Monument Glamping, PPR-22-53

Please accept the following comments from El Paso County Public Health regarding the project referenced above:

Mike McCarthy
El Paso County Public Health
mikemccarthy@elpasoco.com
719-332-5771
06Jan2023

SITE PLAN

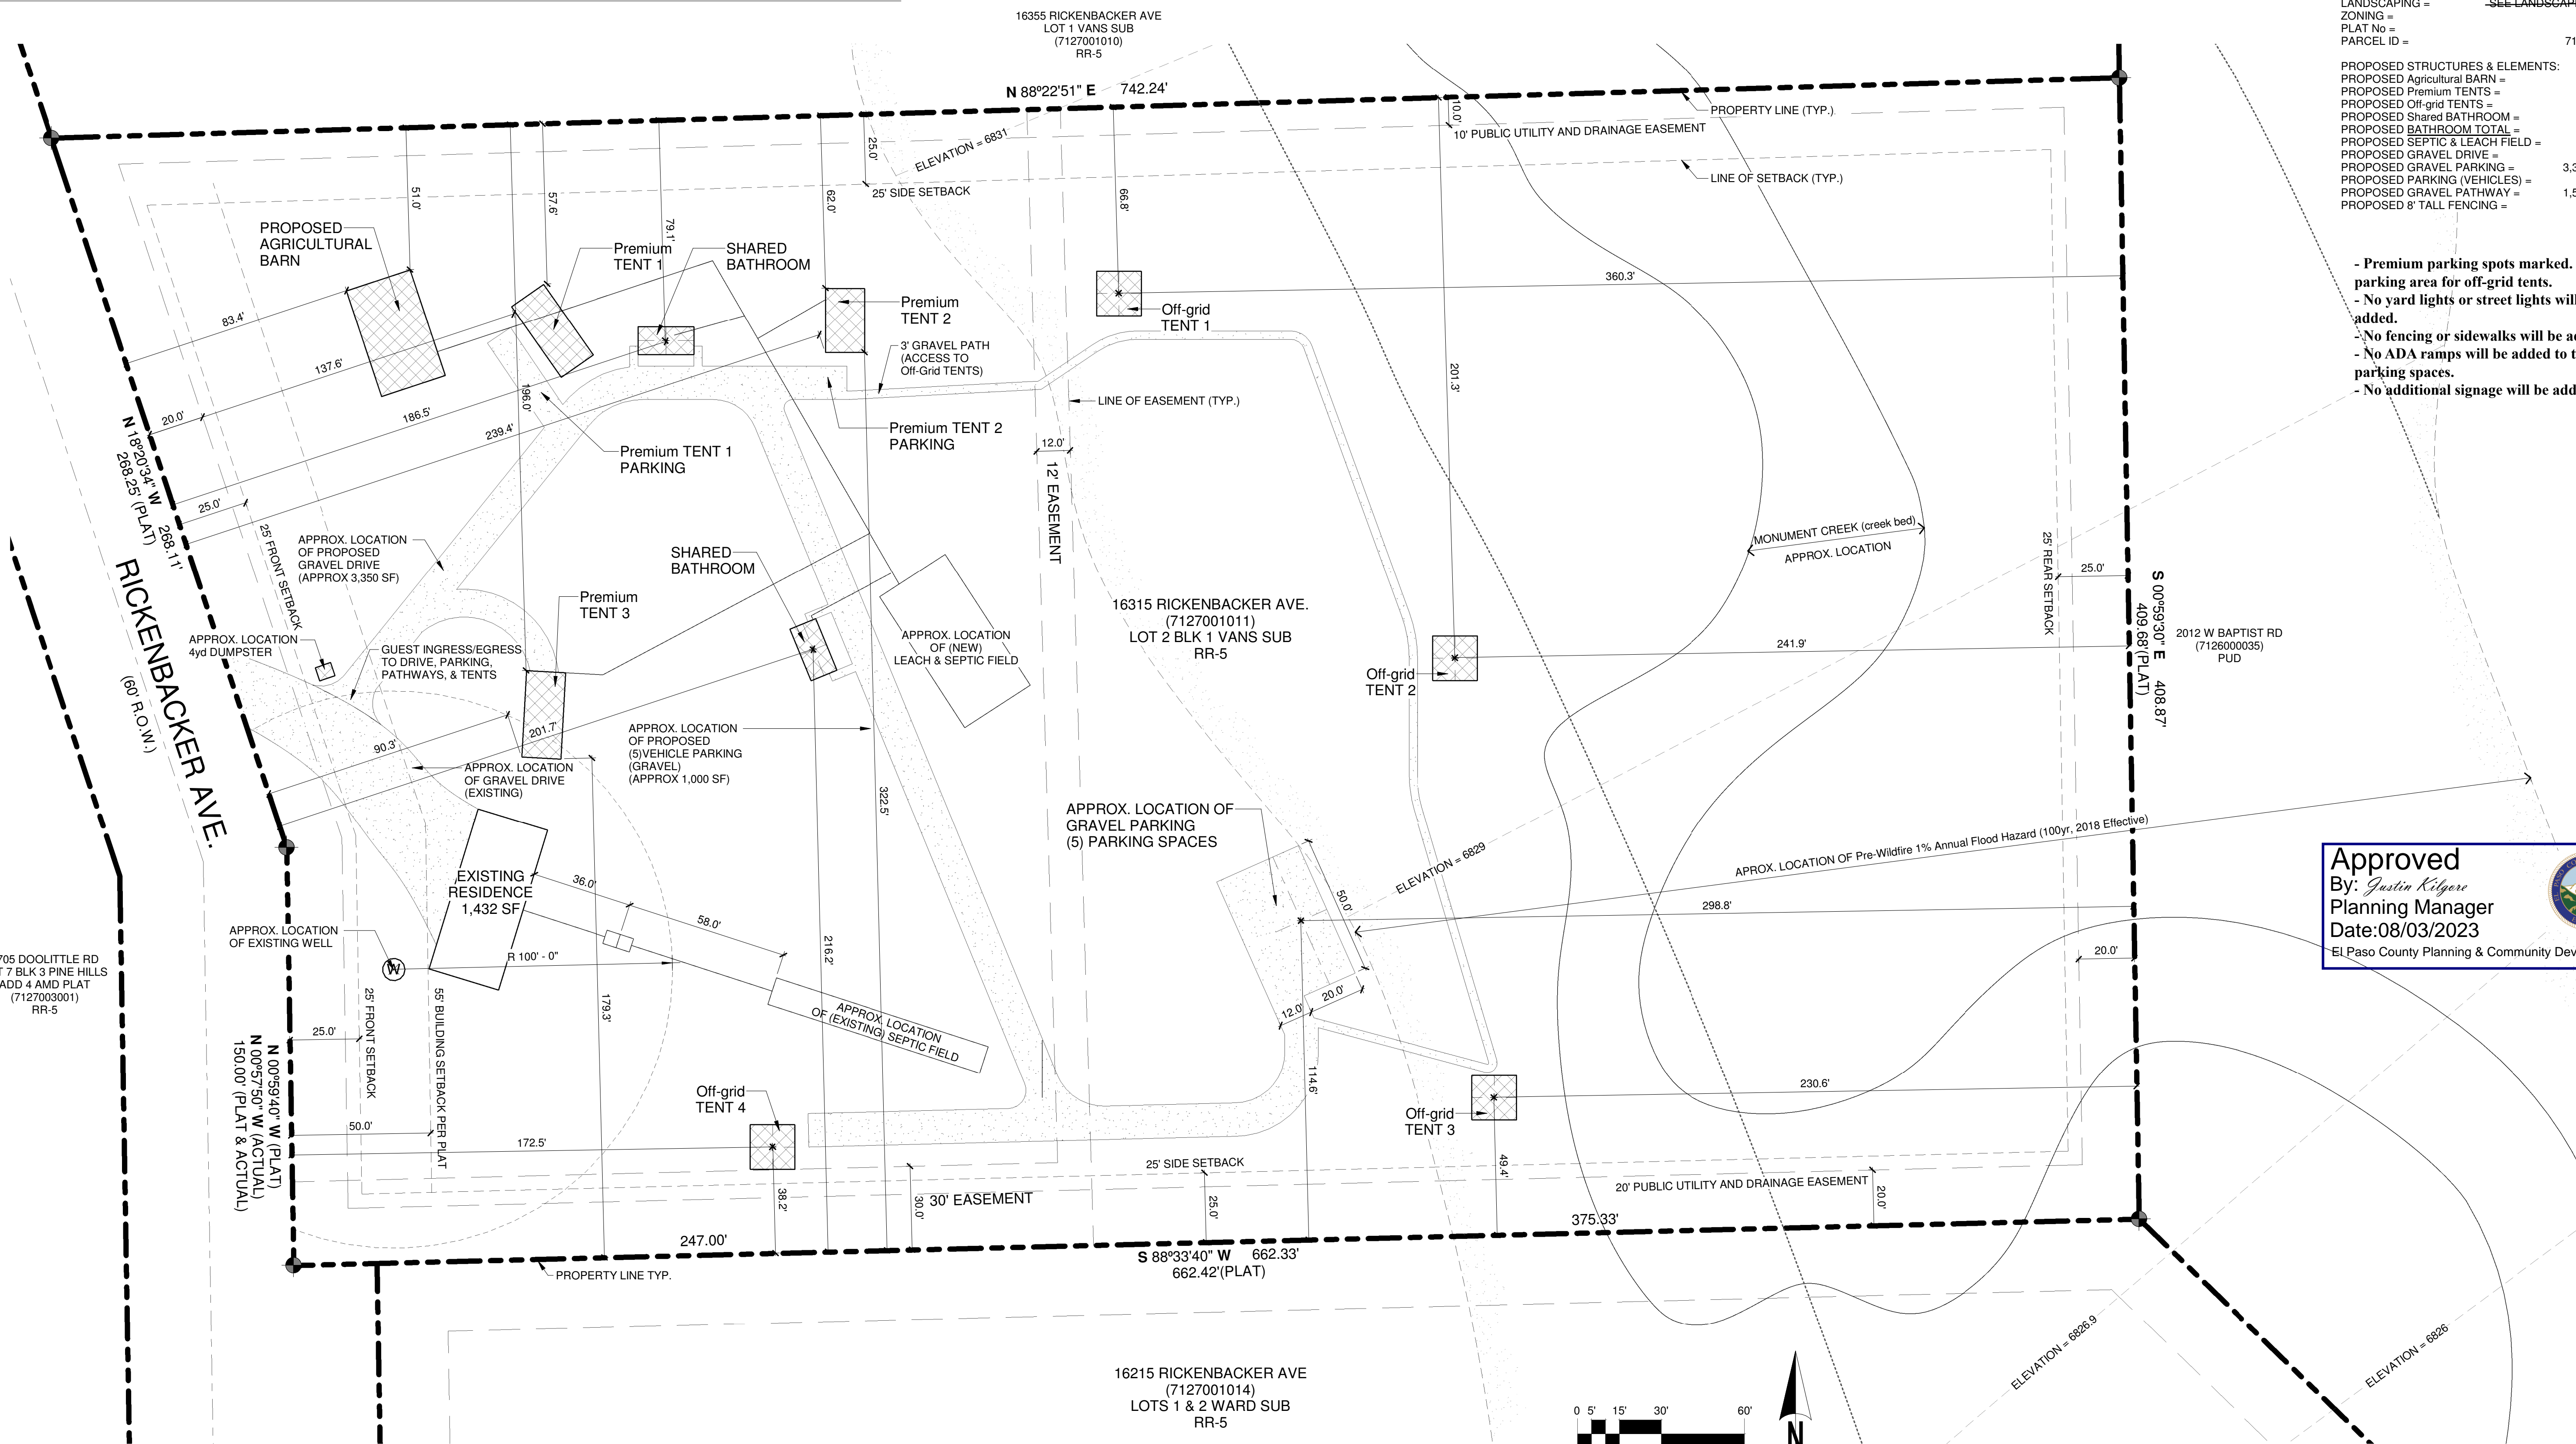
- A record of an approved, permitted on-site wastewater treatment system (OWTS) for this property indicates the OWTS was installed and approved for a 4-bedroom residence in 1991. The OWTS component locations are on file at El Paso County Public Health and accessible through the El Paso County Assessor's Office website property search page. Please make sure that the existing soil treatment area (STA) and a nearby equally size STA replacement area are protected from vehicular traffic and other means of compaction.

- Geoquest, LLC, has submitted an OWTS design that was approved and permitted. Permit # 137172 was issued for the installation. The OWTS installation must comply with all El Paso County Public Health Onsite Wastewater Treatment System Regulations.

# Premium Sites - Elevation Plans

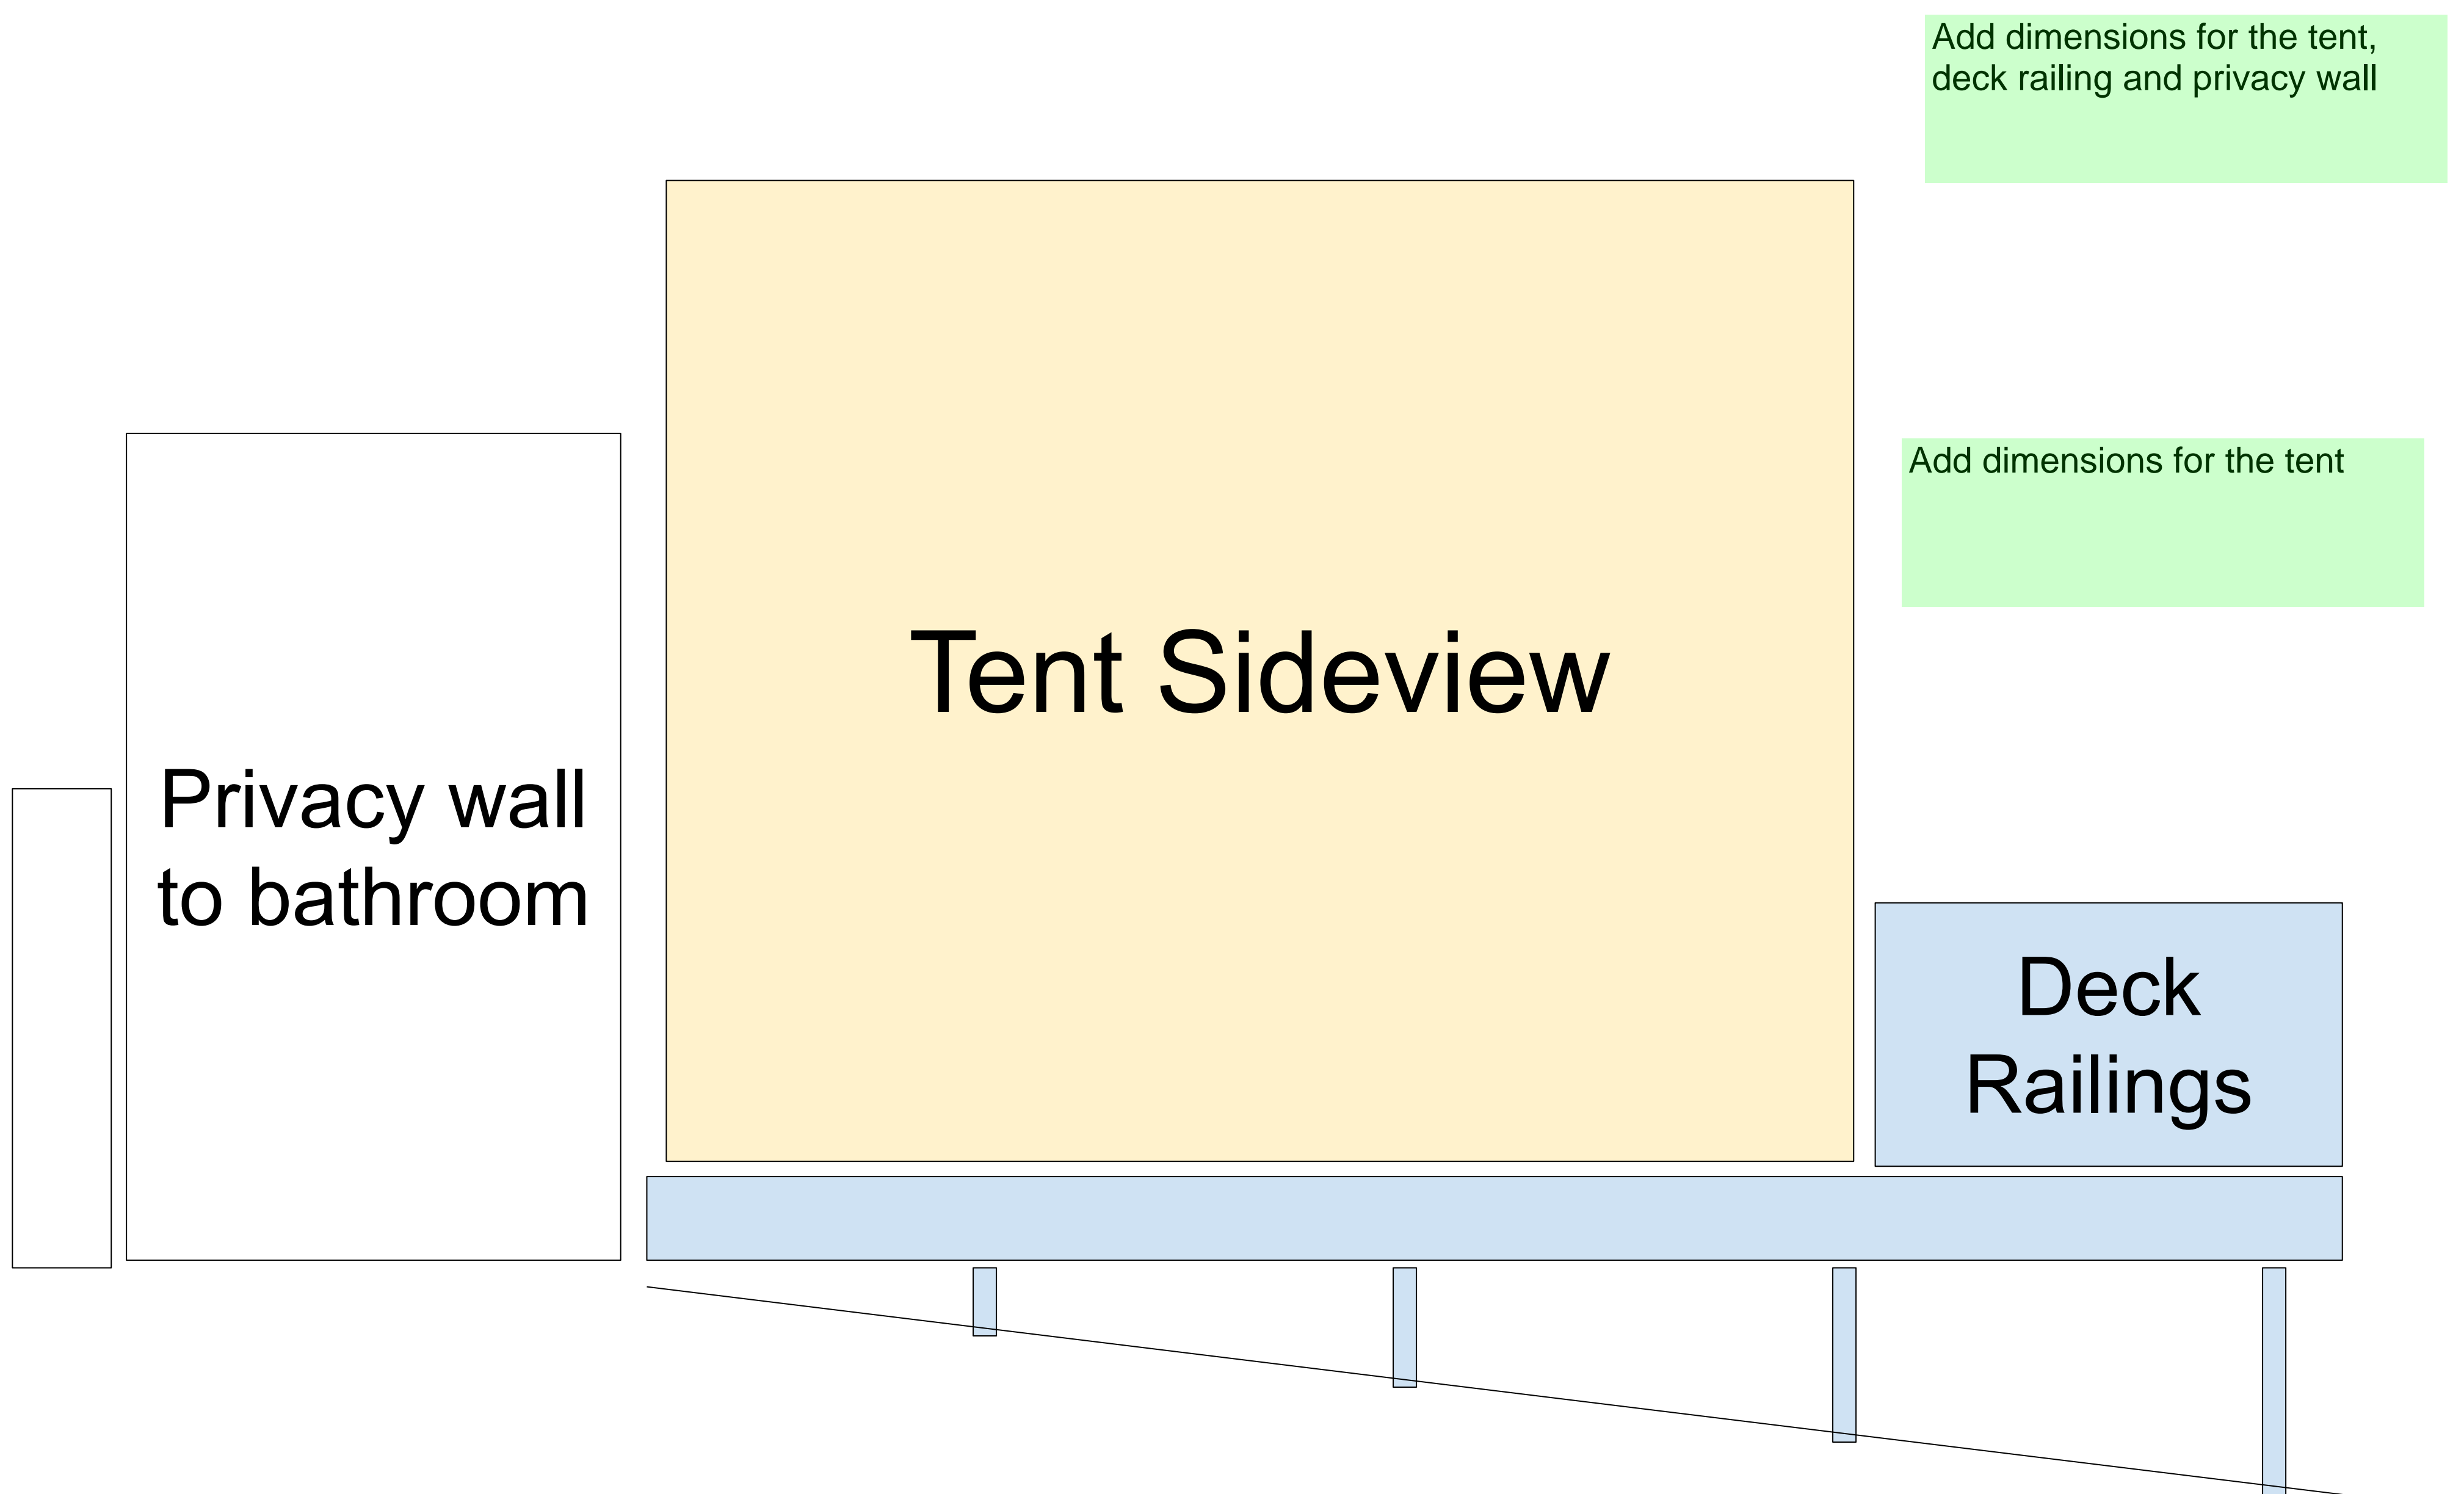
- Please contact El Paso County Public Health at 719-578-3199, option 3, regarding the "private" hot tubs available at the Premium Sites. More information is required on their operation.
